This is to certify that Downs Henry & Brenda J Its owner
 has permission to Remove existing deck to add 1 story addition and new deck
 AT 9 Hope Ln 387 A038001

Comment Date	Comment			
06/29/200	left message w/owner . need to know size of frost wall, wall framing, sheathing, need temp glass framing details			
Name	tmm	Follow Up Date		Completed

Addendum Notes to Plans for Sunroom addition and Deck expansion
at 9 Hope Lane Portland

S ROOM MAIN FRAMING
 DETAIL : 1ST FLOOR

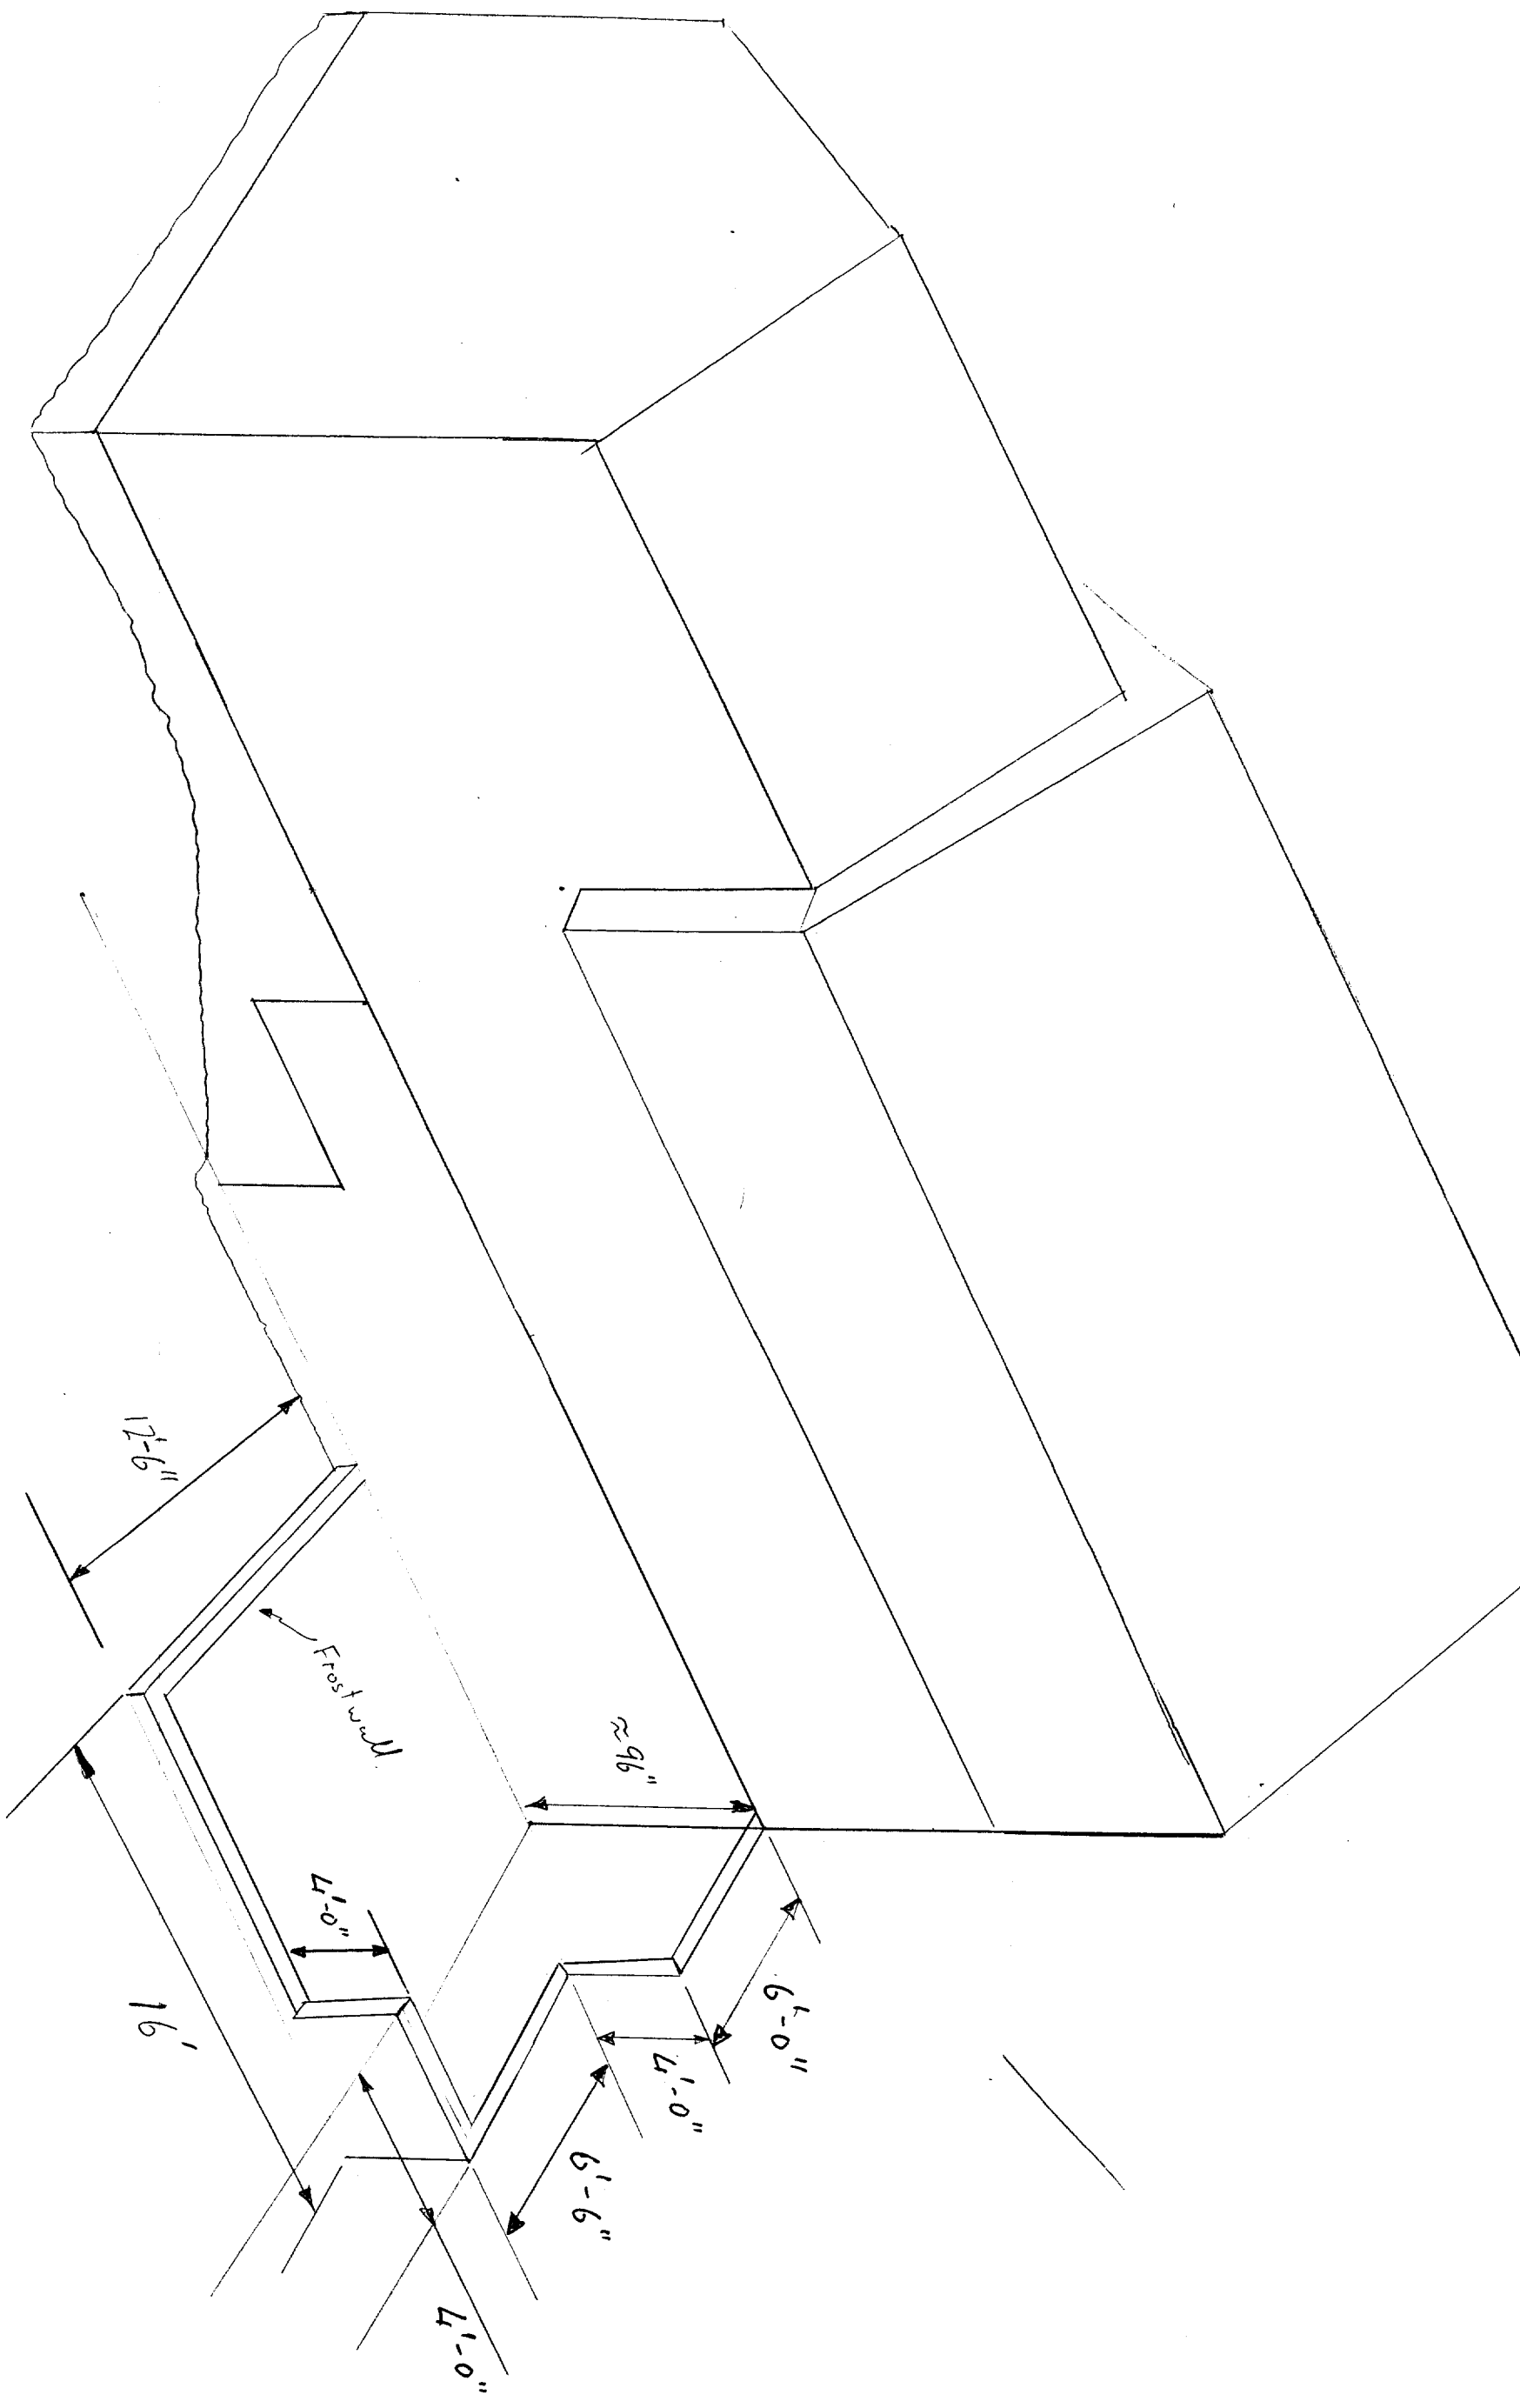
6/29/05-tmm: left message w/owner - need to know size of frost wall, wall framing, sheathing, need temp glass, deck framing details.

1. Framing and support details for the deck expansion are attached as part of this addendum.
2. Foundation specifications are attached as part of this addendum and will be added to design prints as required.
- ✓ 3. Any windows within 24" of a door opening AND/OR within 18" of the floor will be of tempered glass design.
- ✓ 4. Wall Sheathing to be 7/16 waferboard as approved by city codes.
- ✓ 5. Flooring to be 3/4 T & G underlayment.
- ✓ 6. Roofing sheathing to be 5/8 T & G plywood.
